Ecology and Biodiversity Net Gain response

From: Jonathan Best <Jonathan.Best@arun.gov.uk>
Sent: 02 January 2025 14:35
To: Planning.Responses <Planning.Responses@arun.gov.uk>
Cc: Amber Willard <Amber.Willard@arun.gov.uk>
Subject: WA/102/24/PL

Longacre The Street Walberton BN18 0PY.

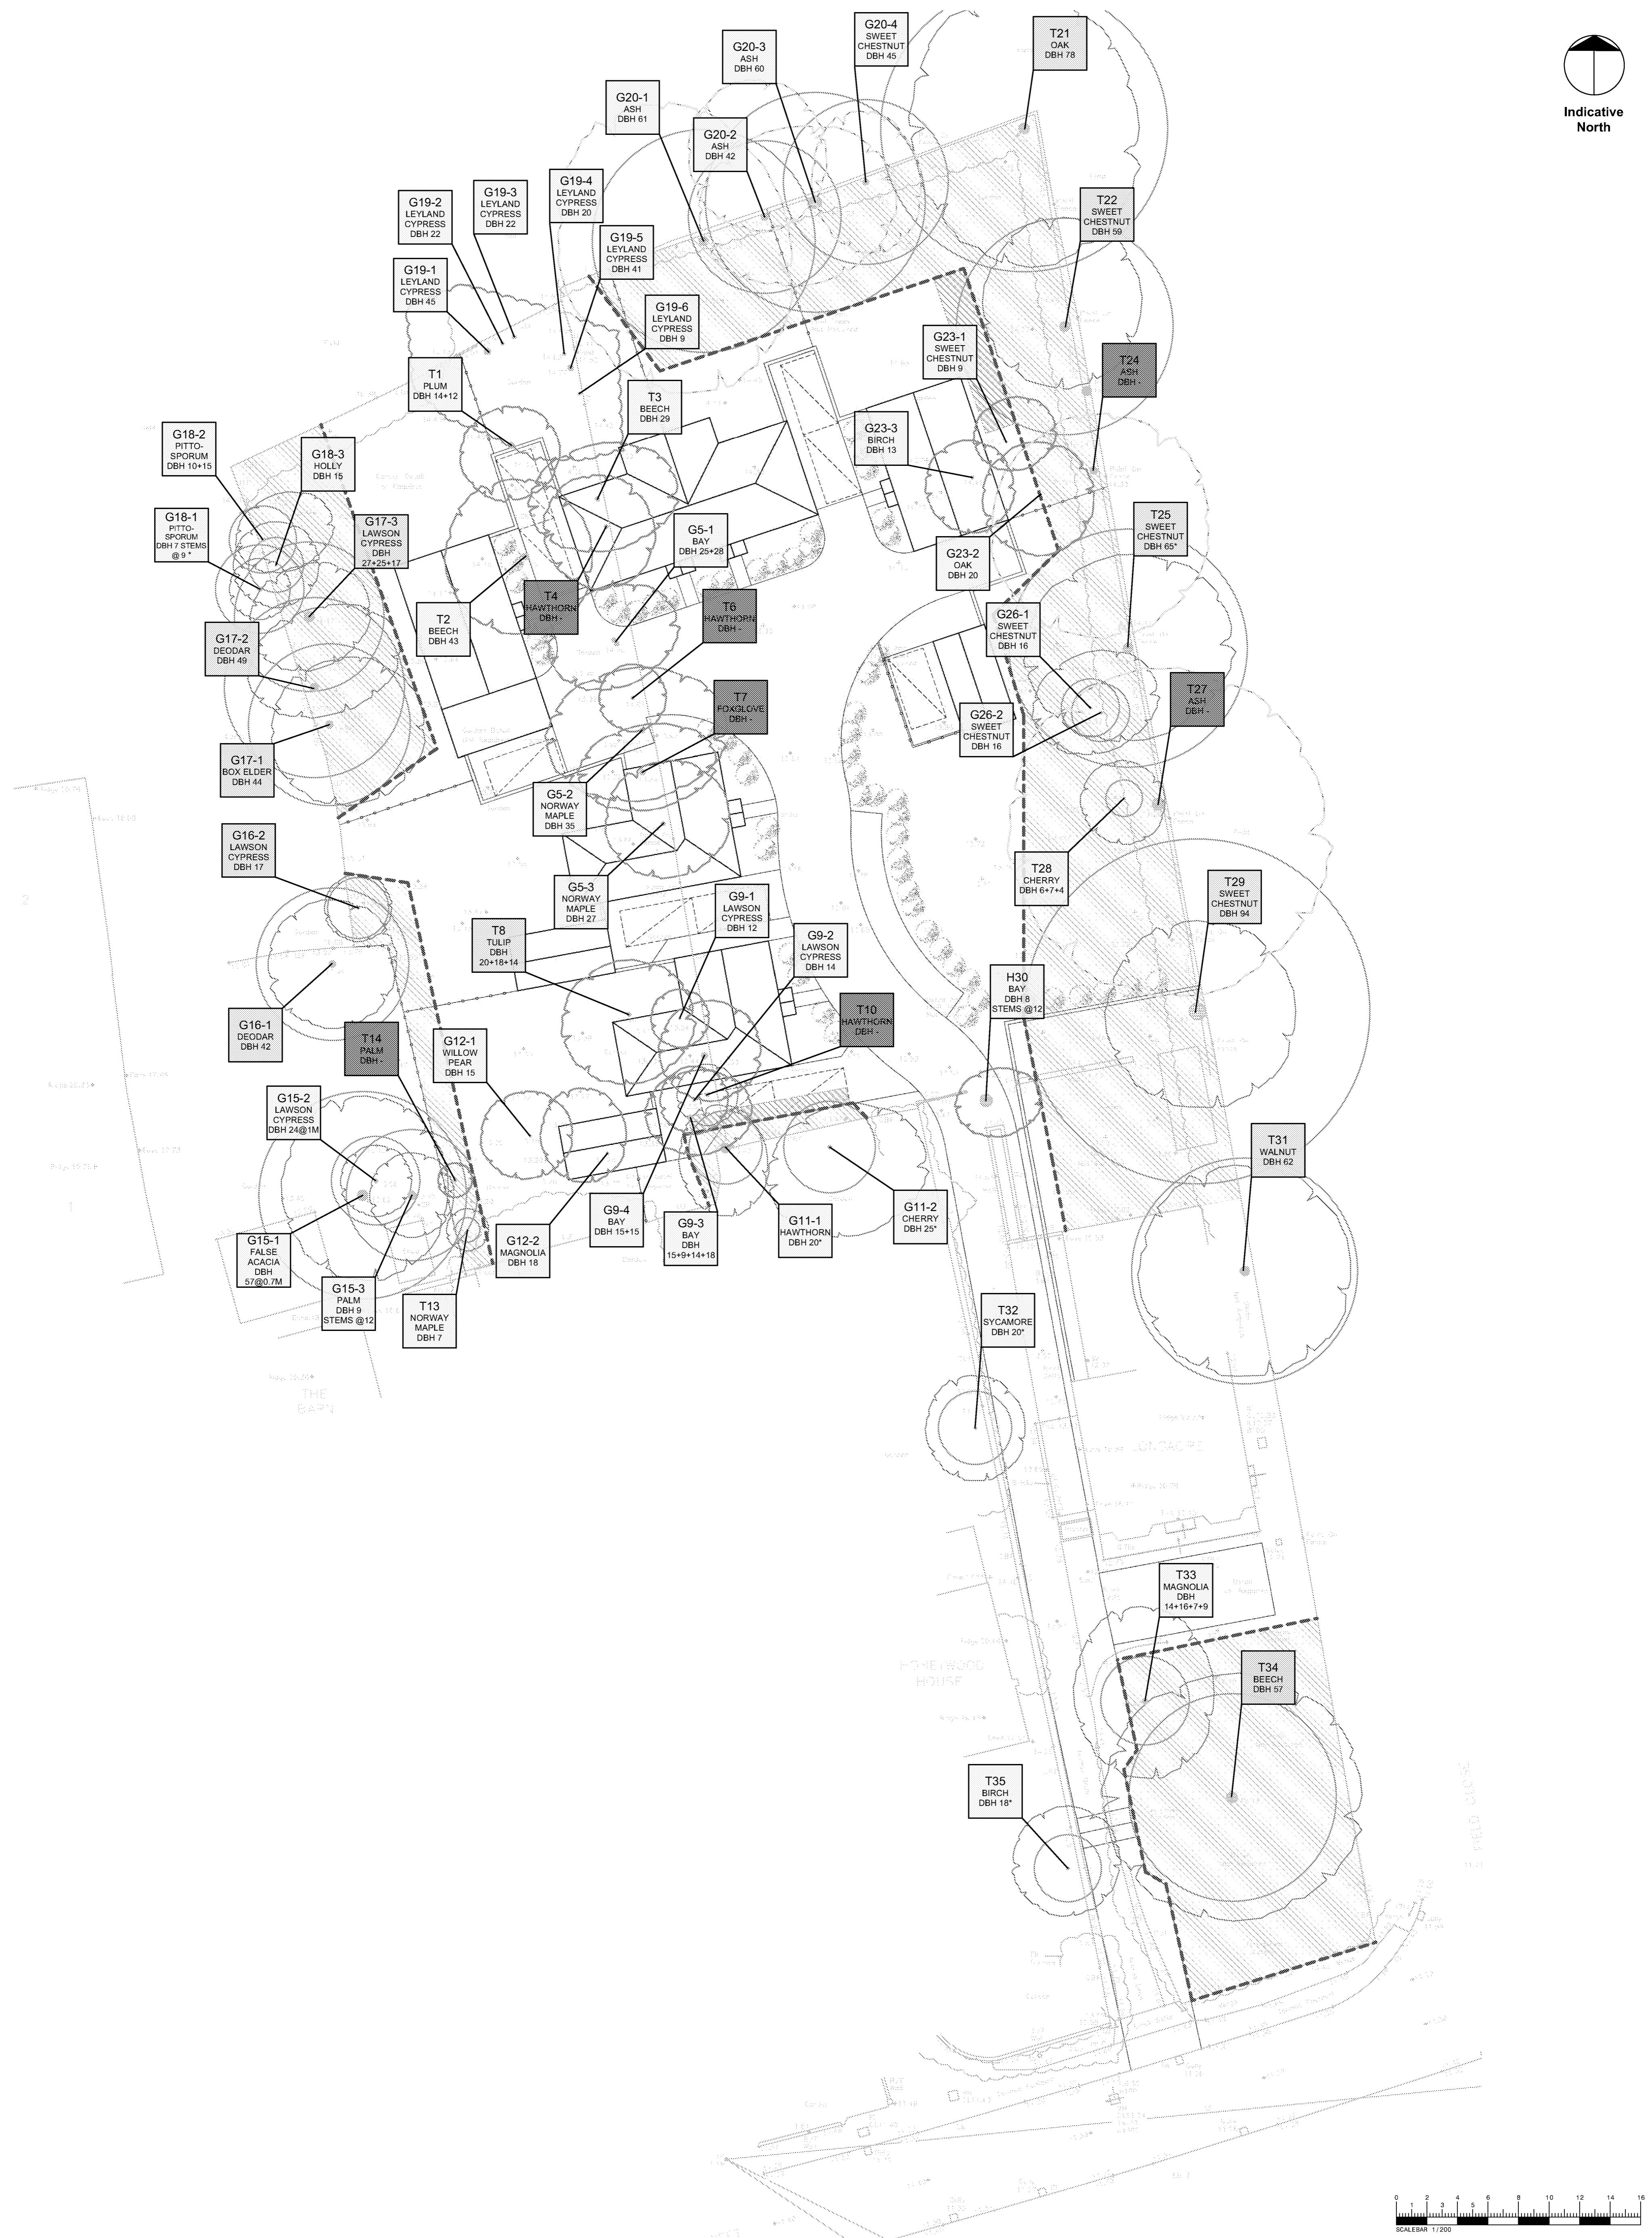
The figure for habitats may not be correct because there are a number of trees or groups of trees that should have been recorded within the metric as advised by the Statutory Biodiversity Metric User Guide. See Page 55.

Trees with over 30cm stem diameter should be recorded in the metric and the condition assessment. Only vegetated garden has been recorded in the submitted metric. The Arboricultural implications assessment and method statement identifies 12 individual or groups of trees that are over 30cm in diameter.

Several of these are proposed for removal.

The metric should be updated as it may well show a different result once the trees have been taken into account.

Further details of the trees within the Metric are required.
